From: Jeffrey Manchester
Sent: Tuesday, September 20, 2022 4:42 PM
To: Joe DesJardin; Kevin Kofford (kevin.kofford@kimley-horn.com); Sean Kellar (skellar@kellarengineering.com)
Cc: Andrew Biggs; Charlie Williams; Jack Ladley; Kevin Mastin; Joshua Palmer; Elizabeth Nijkamp; Gilbert LaForce; Brad Walters; Chris Bland
Subject: RE: Revised Intersection
Attachments: EPC Comment Summary - 2022_09_20.pdf; 2022-09-16 Winsome Way Intersection REVISED-RedlineGLF-Sheet3.pdf

El Paso County Review Comments

Geometric Design Plans Submitted by Kimley-Horn (dated 09/16/2022)

WINSOME FILING NO. 1
 EL PASO COUNTY, COLORADO
 CONSTRUCTION DOCUMENTS
 EB-NB LEFT TURN

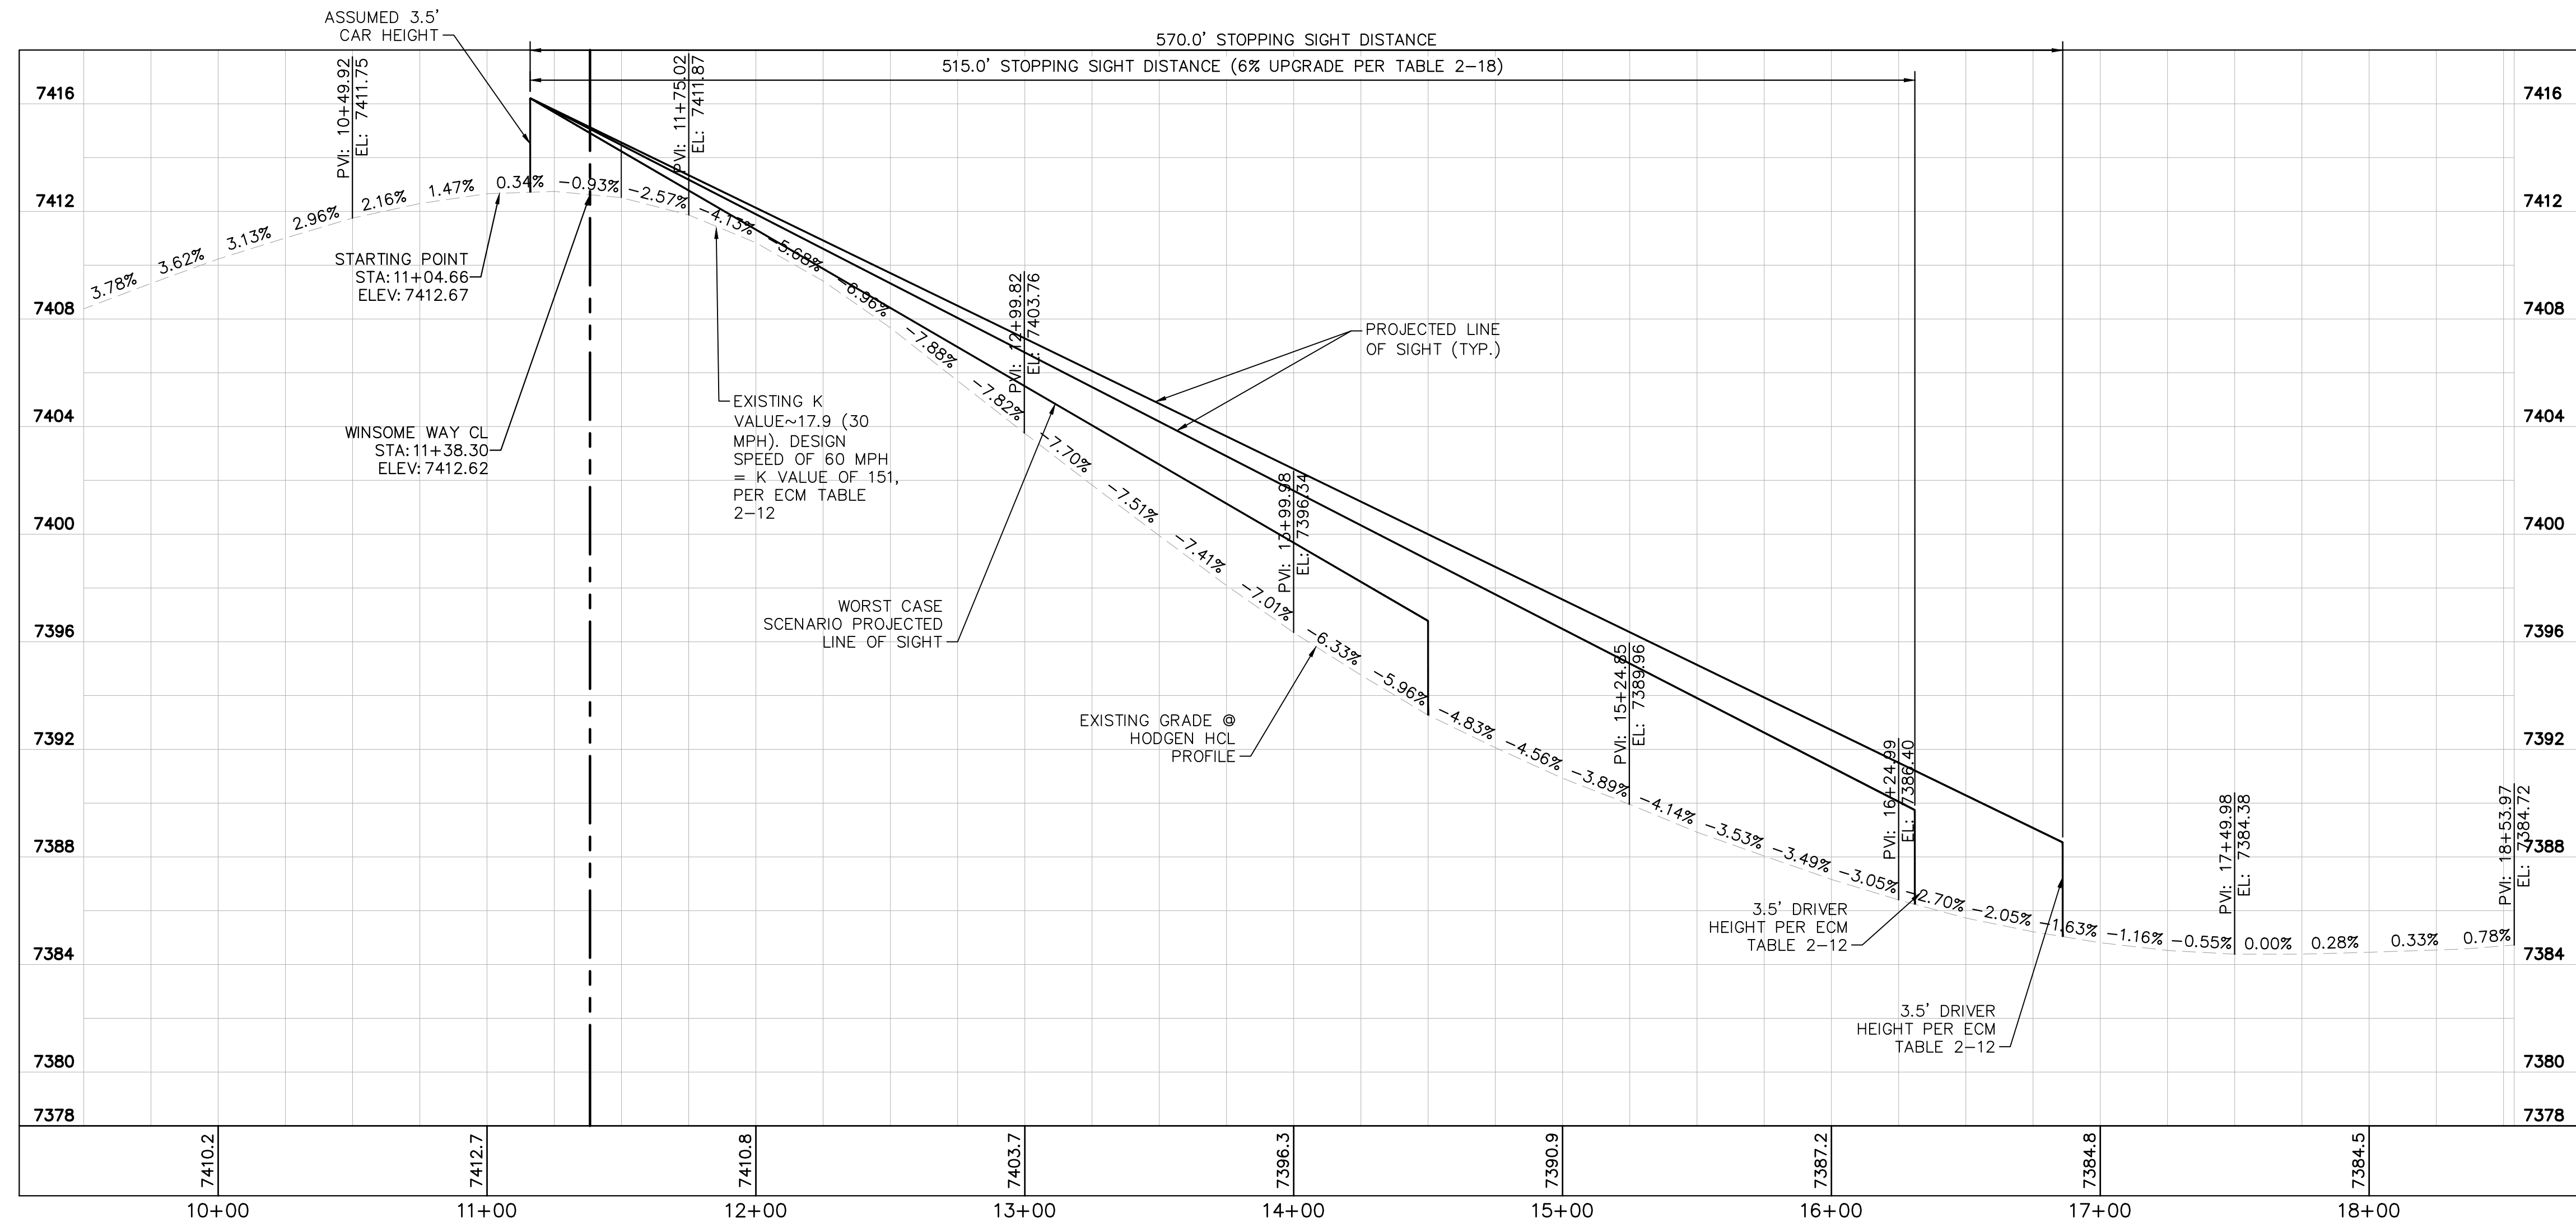
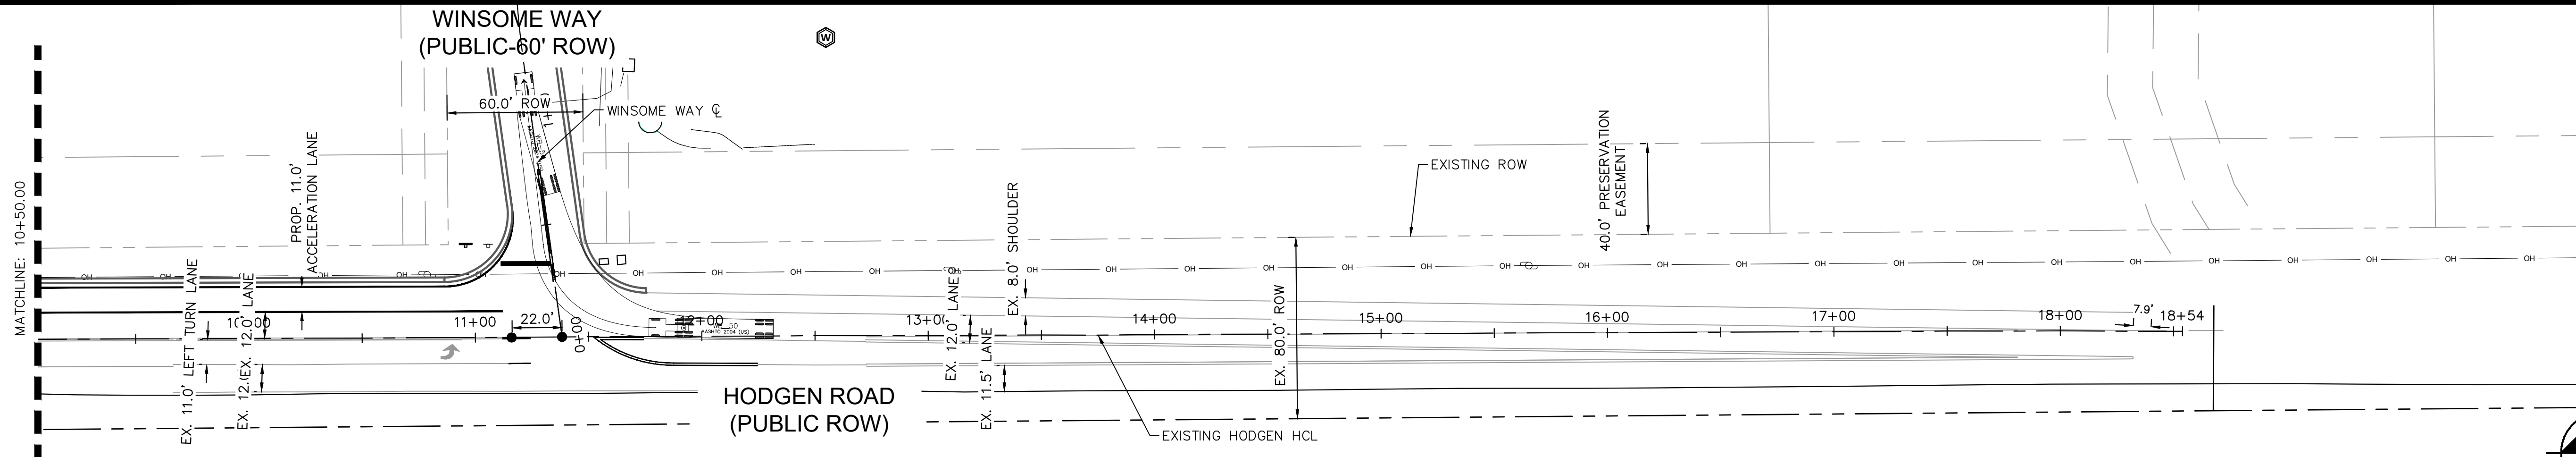
- c. Sight distance for WB-50 needs to be shown (same as comment 1.a above).
 - d. Stop bar for Winsome Way needs to be set 13' from edge of pavement in alignment with intersection sight distance criteria.

WINSOME FILING NO. 1
 EL PASO COUNTY, COLORADO
 CONSTRUCTION DOCUMENTS
WB-50 TURNING TEMPLATE

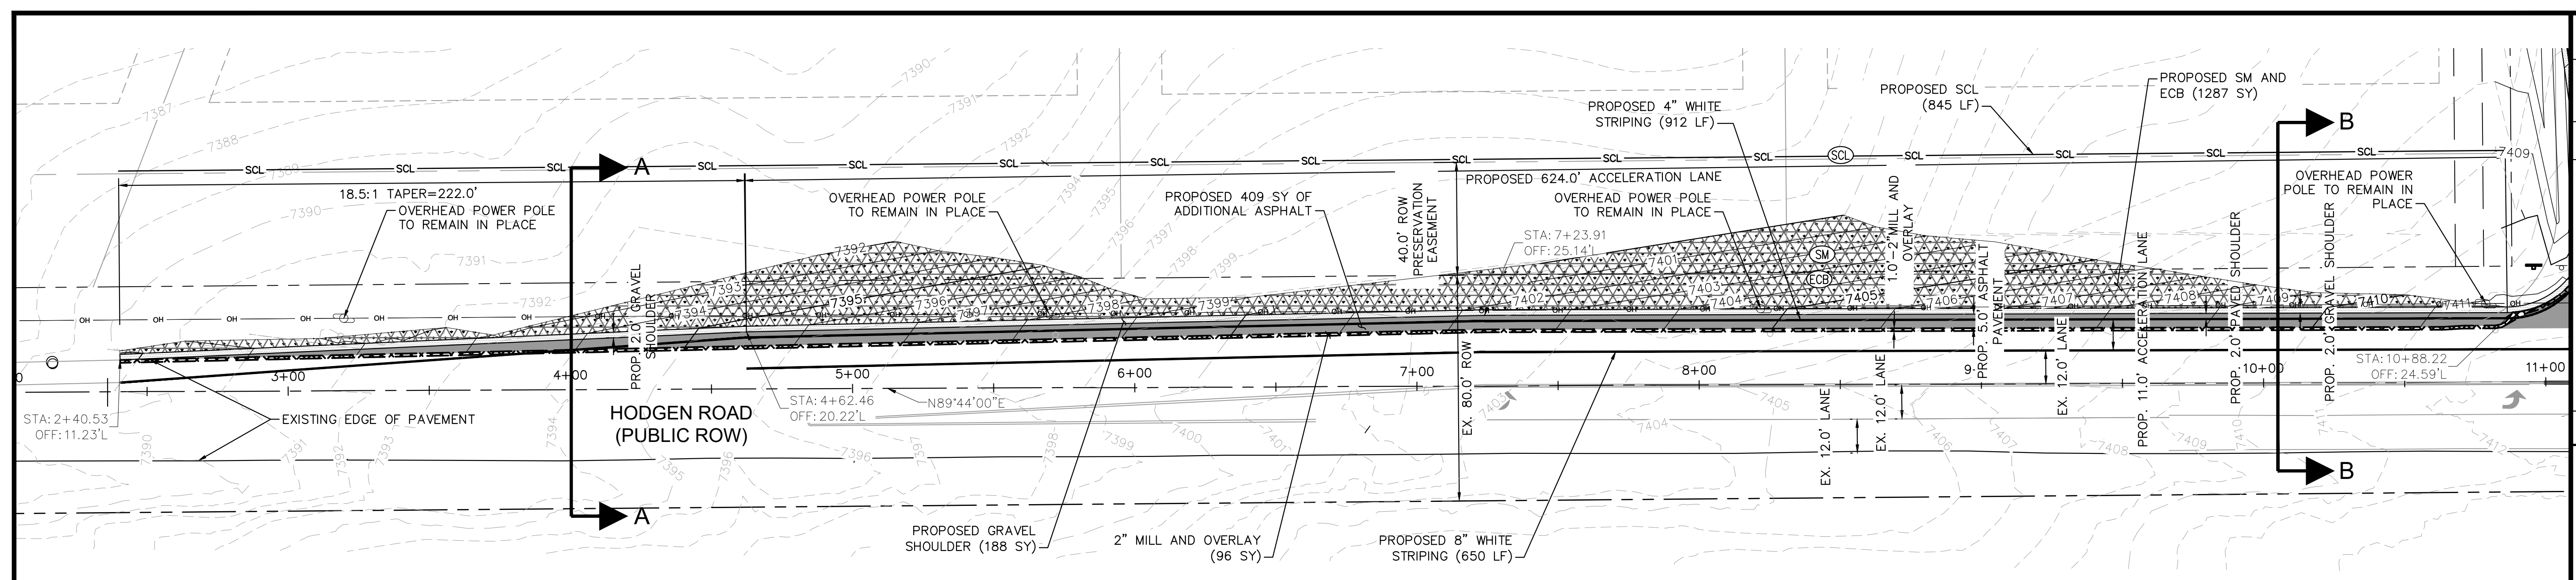
- c. Delete "proposed dog tracks". This is conflicting with median opening clear zone.
3. Sheet 3 of pdf
 - a. WB-50 is off-pavement in turning movement and not allowed per criteria (ECM 2.3.7.G.3). Adjust pavement width to accommodate.

- b. Clear Zone Requirements not met
 - i. If clear zone requirements are not met, existing utilities need to be protected by an appropriate protection device, e.g. barrier. In reviewing the plan, this would apply to the existing utility pedestals and the overhead electrical pole.
